CITY OF ALBUQUERQUE

**Re: Gibson Yale Commercial Traffic Impact Study
5200 Gibson SE & 2121 Yale SE
Traffic Impact Study, Final received 12/14/2021
HT#M15D021, Engineer seal 10/29/2021**

The City of Albuquerque Planning Transportation Department has reviewed the Gibson Yale Commercial Traffic Impact Study dated 10/29/2021. The City has comments to be addressed acceptably before approval of the traffic study.

PRIME PROPERTIES
GIBSON BOULEVARD RIGHT-OF-WAY EXHIBIT
2121 YALE BOULEVARD
CITY OF ALBUQUERQUE, COUNTY OF BERNALILLO,
STATE OF NEW MEXICO

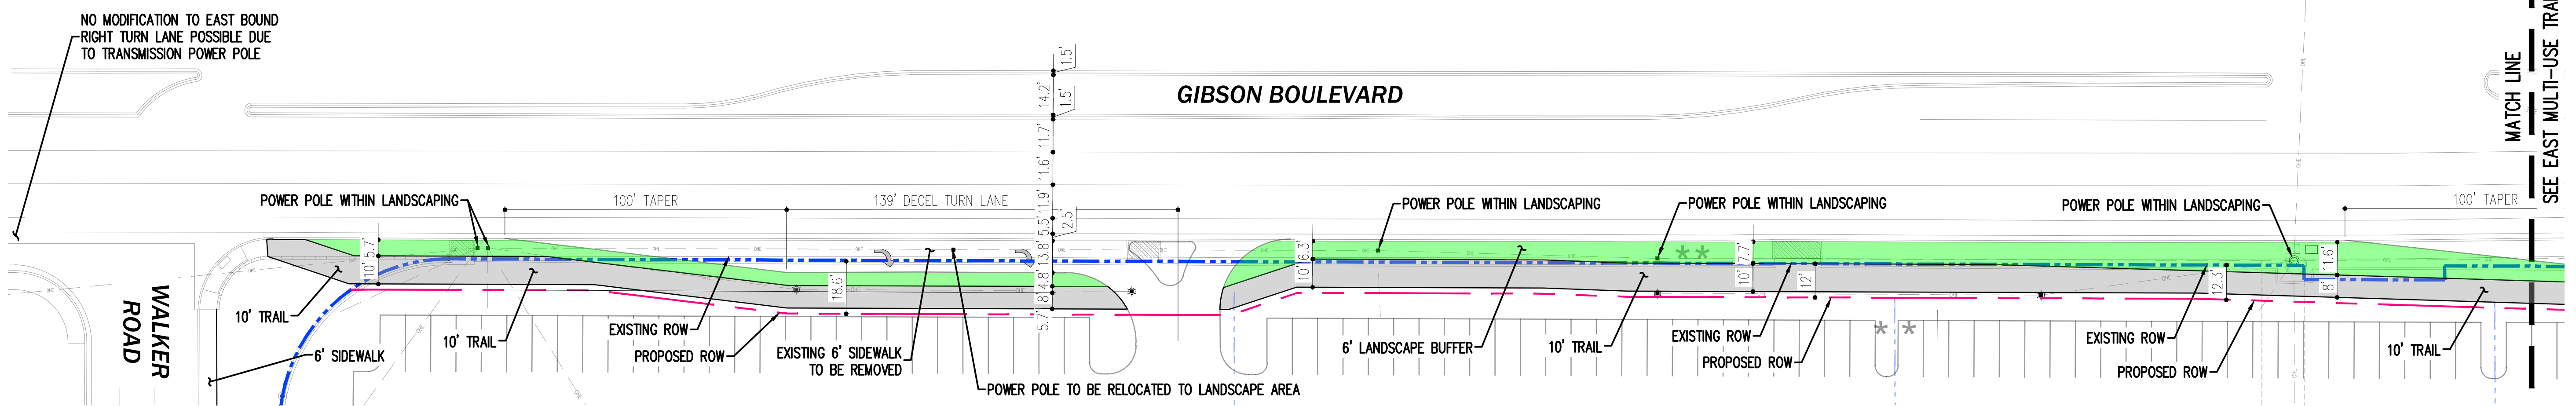
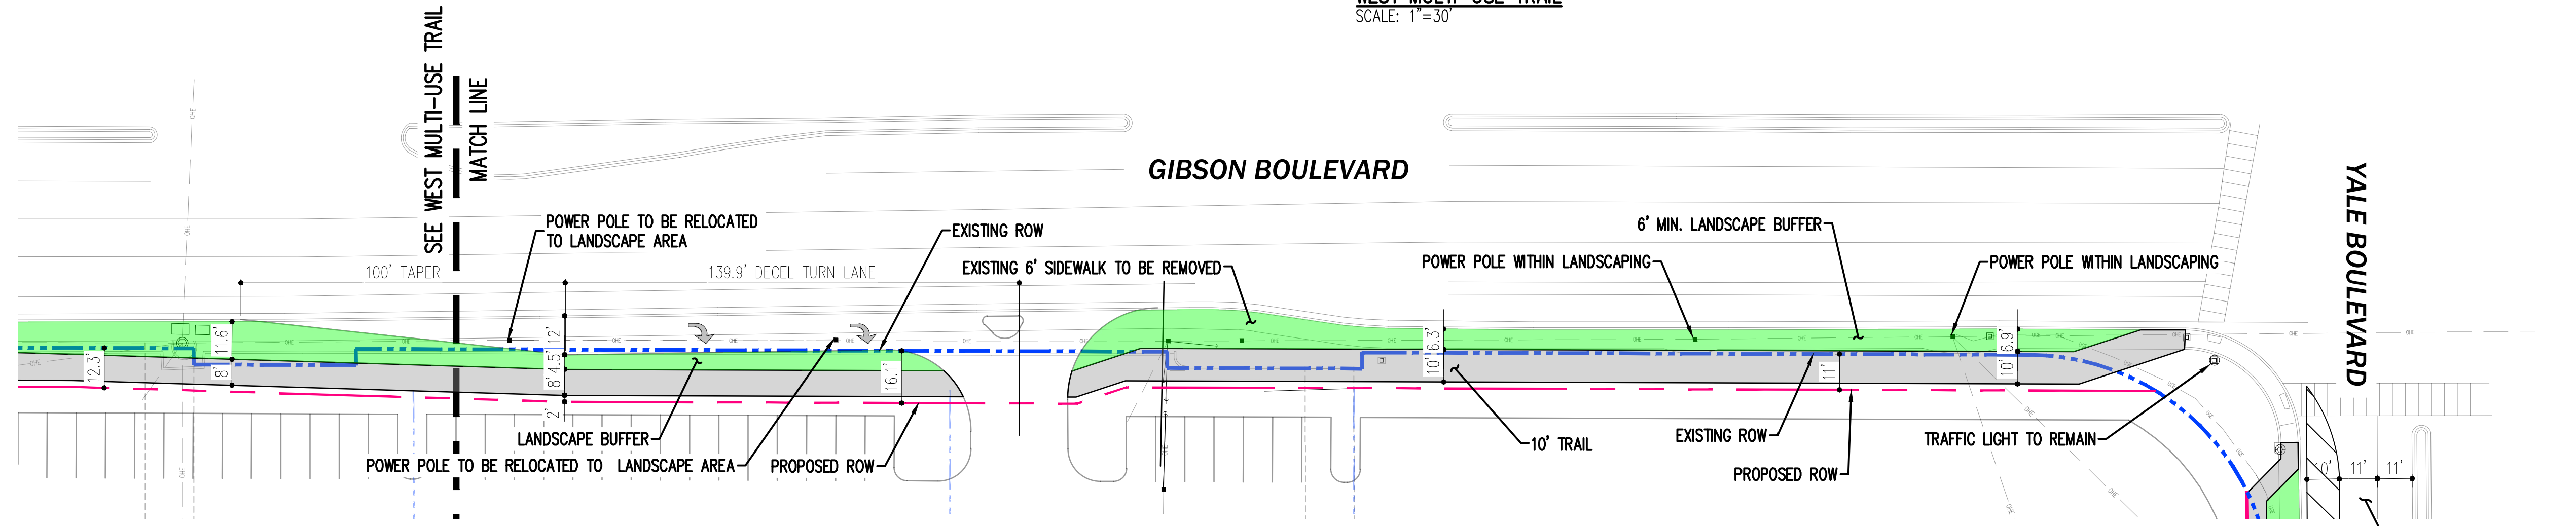
1. Revise the right turn lane transition on Gibson Blvd. shown on the site plan Right-of-Way Exhibit in Appendix A from 100-foot taper to asymmetrical 300'-150' reverse curves. The existing geometric restrictions prevent the required turn lane storage length and transition for the posted speed limit of 45 MPH from being feasible create a condition where the recommended 600'-300' asymmetrical reverse curves and 350 feet of storage is not possible. The ~139 feet of storage will be acceptable.

PRIME PROPERTIES
MILES ROAD RIGHT-OF-WAY EXHIBIT
2121 YALE BOULEVARD
CITY OF ALBUQUERQUE, COUNTY OF BERNALILLO,
STATE OF NEW MEXICO

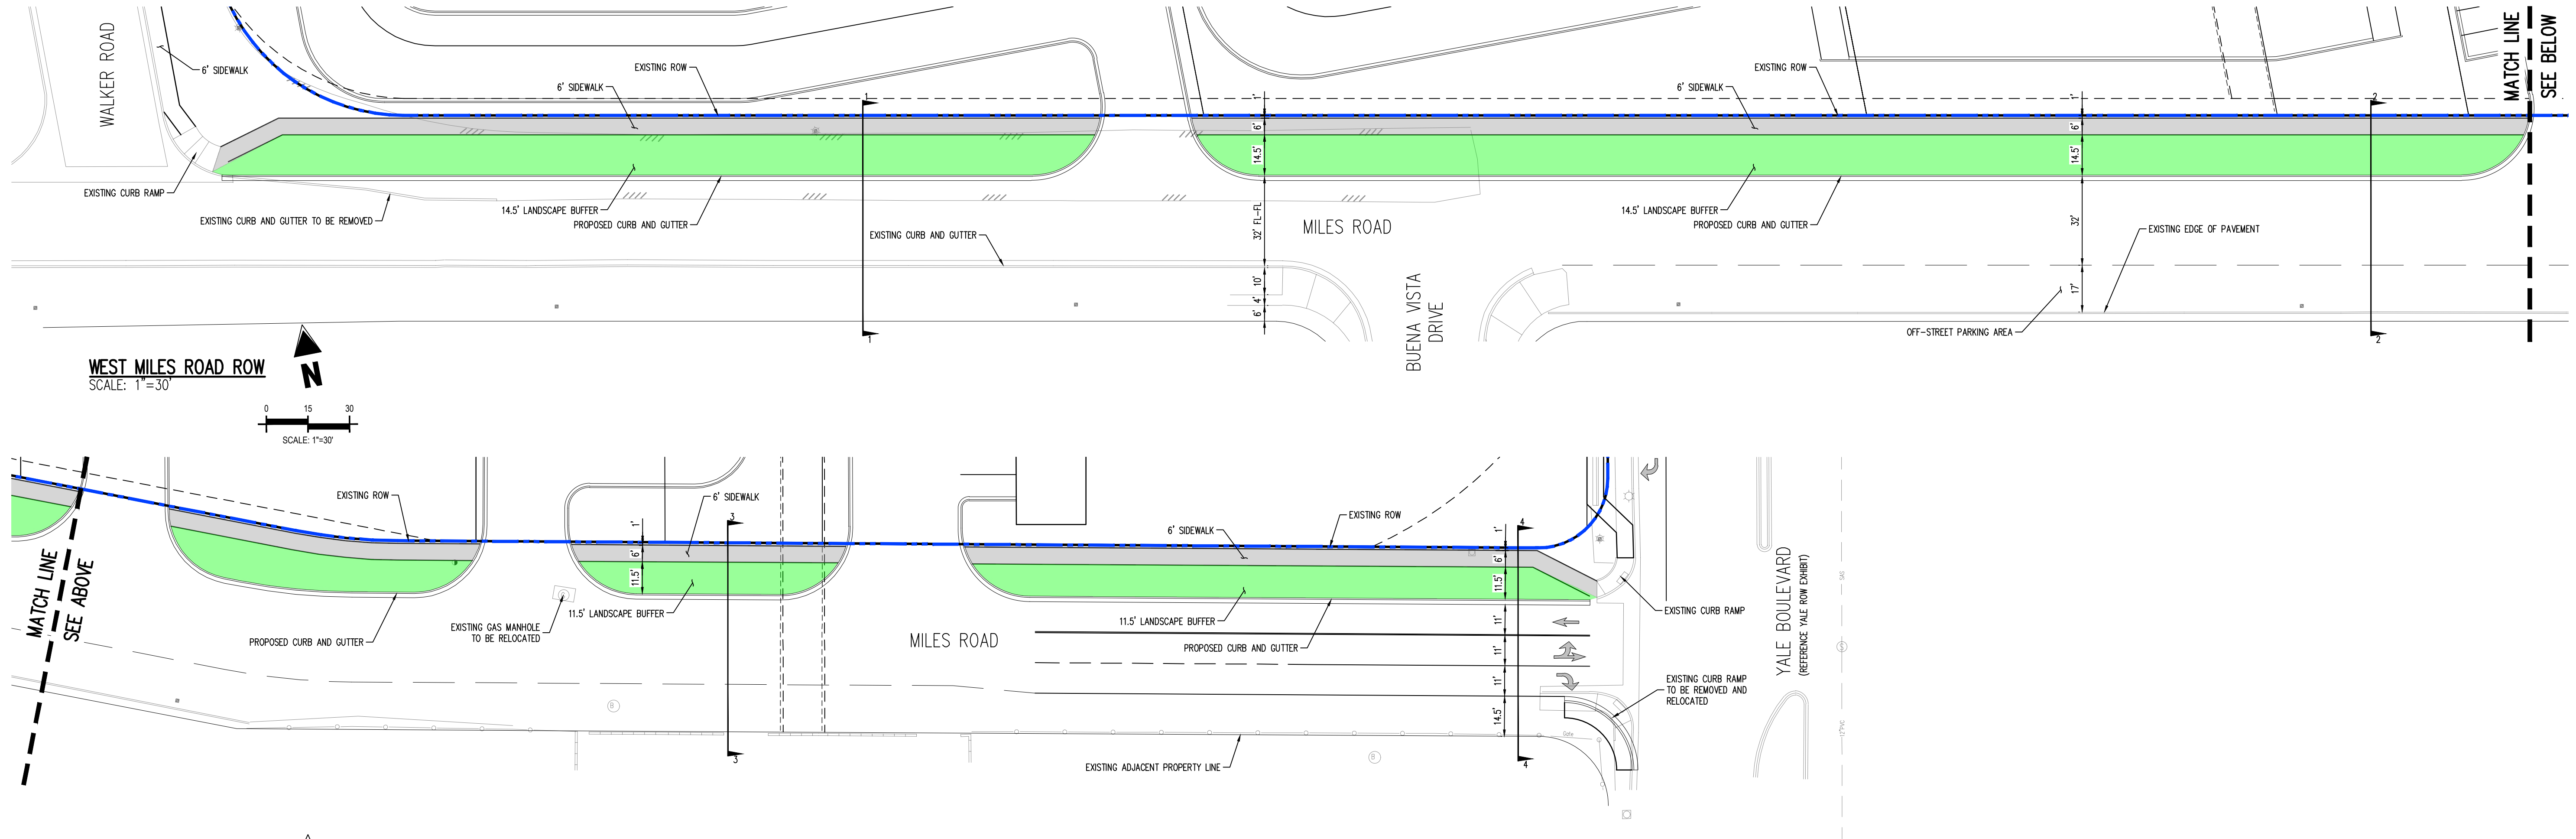
2. The southbound right turn on Yale Blvd. at Miles Road shall be constructed as a raised curb and gutter. A taper transition with reduced storage length is acceptable. The curb return and ADA ramps on the southwest corner are to be reconstructed to accommodate the new right turn lane on Yale.

3. Include refreshing the pavement markings and striping for; the southbound approach of Yale Blvd. at Gibson Blvd., on Miles Rd. from Yale to Walker Rd. and the southbound departure on Yale Blvd. from Gibson Blvd. to Miles Rd. Include the replacement of traffic signs as needed.
